# CITY OF ALBUQUERQUE

PLANNING DEPARTMENT – Development & Building Services

RE: **Sagebrush Plaza, Tract 1-D-1-A**, Blk 15, Alban Hills - Grading and Drainage Plan  
NE Corner of Coors & La Orilla NW P.E. Stamp: 11/5/12 File # **D12-D006**

**ROUGH GRADING**

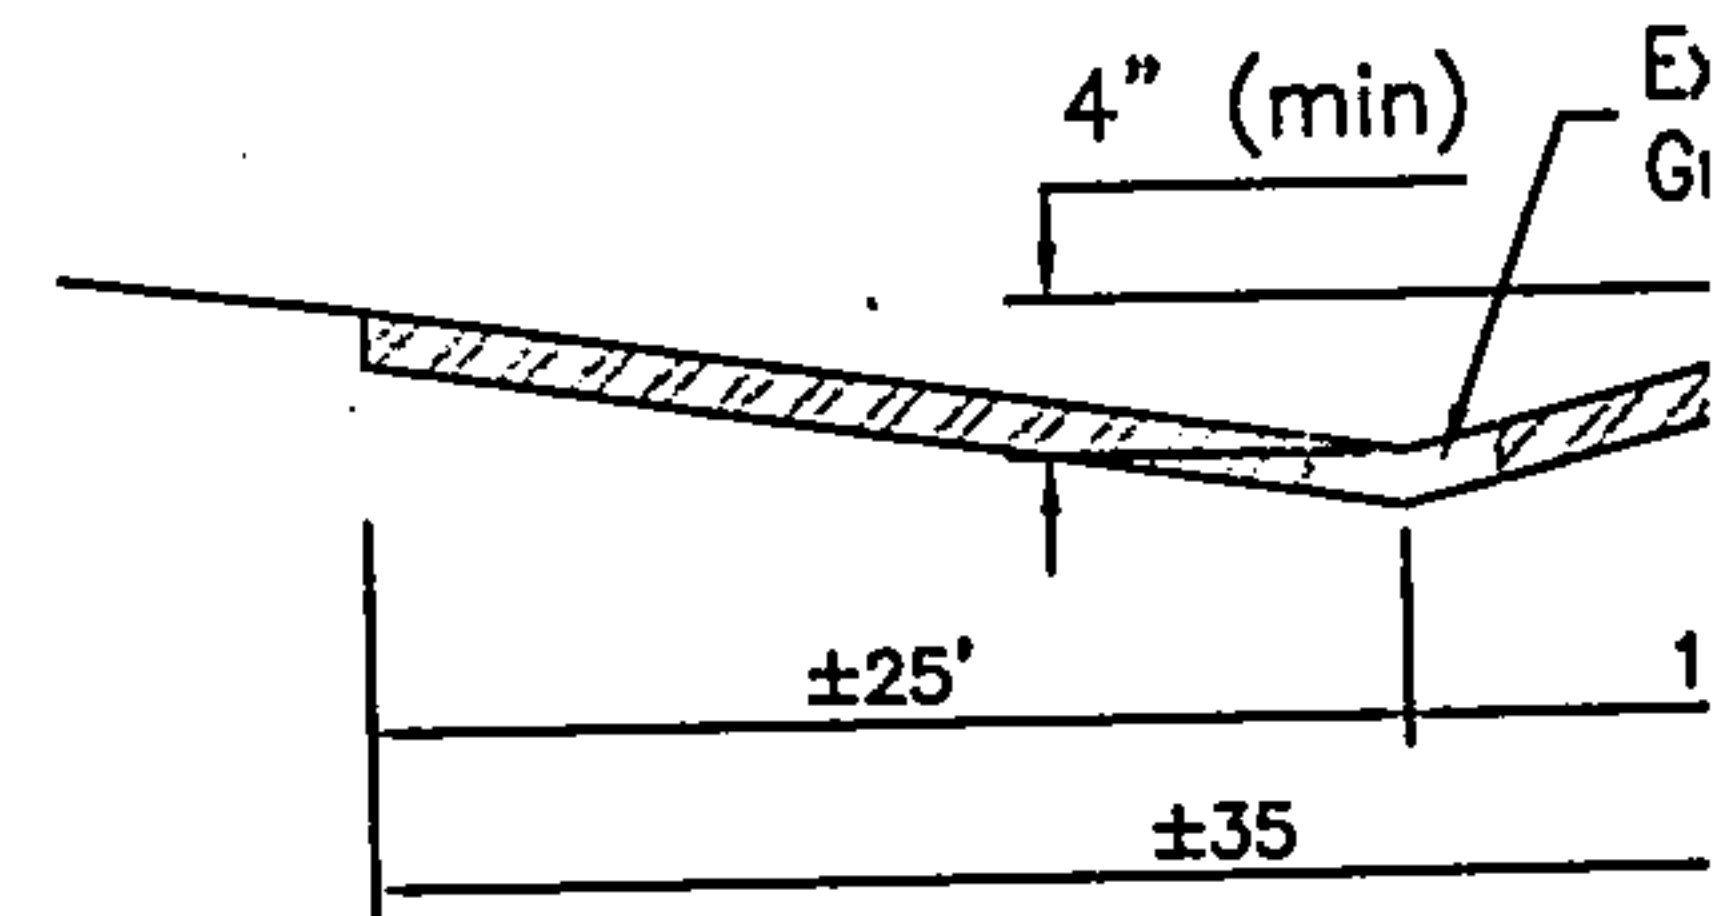
2. **East Side Channel appears to be too small.** Calculation included used a Manning’s n-factor of 0.025 for a cobble surface. DPM and FHWA references suggest that this value should be higher; between 0.035 and 0.050. However, the Site Plan submitted 12/4/12 included a landscaping plan with “Gravel Mulch” ground cover in the channel. It also includes plantings, which will inhibit flow in the channel. The design concept seems fixable, by adjusting calculations to reflect actual landscaping surfaces, and recognizing additional capacity in the pavement west of the channel, via the proposed curb openings. My only remaining concern is at the southern 85’ of the channel (Section A-A), where there is no freeboard to inhibit overflow and erosion on the adjacent lot to the east.

3. **Clearly show the limits of the existing, retaining wall** (Section B-B) adjacent to the channel. Section A-A is beyond the south end of the existing retaining wall, and proposes grading on the adjacent property. Is this grading approved by the owners of that property?

4. **Missing flow line elevations in La Orilla Rd** at the drive entrance are requested to aid in confirmation of an adequate water block on the church site to the east. Provide the grades on La Orilla, and some additional spot elevations along the flow-line of the pavement/swale, upstream of where flow crosses easterly to the church site.

C7

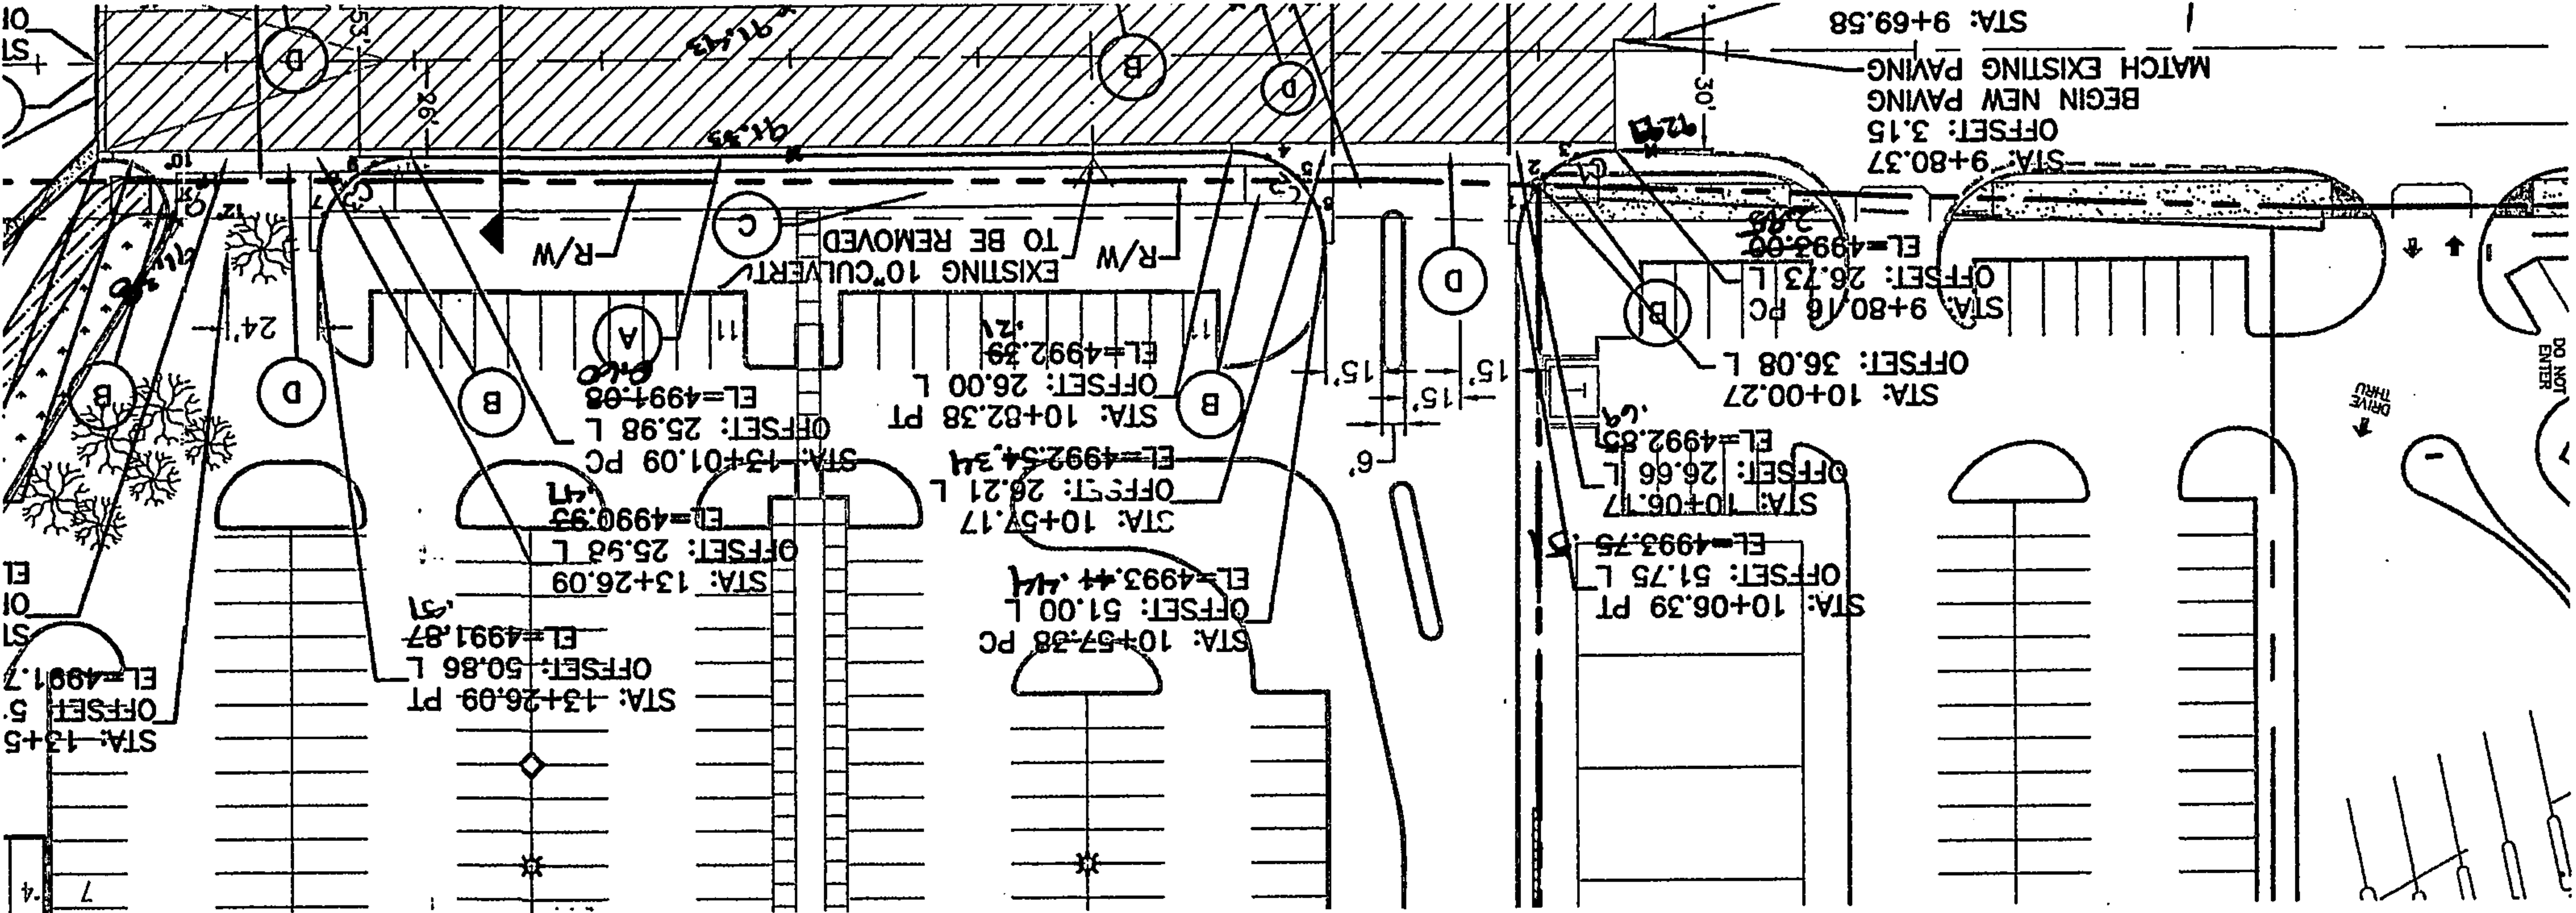
5. **A depressed Landscaping area** is shown between Buildings A and B, and paving grades slope toward this area, which would function well for water harvesting, however no curb cuts are shown to allow runoff to enter the depressed area. This condition traps

water in the parking spaces on the south side of the area. Also, the Administrative Amendment documentation which you submitted 12/4/12, shows this area as "Future Outdoor Dining/Customer Waiting Area." Would this water harvesting area be eliminated by "Future" site improvements?
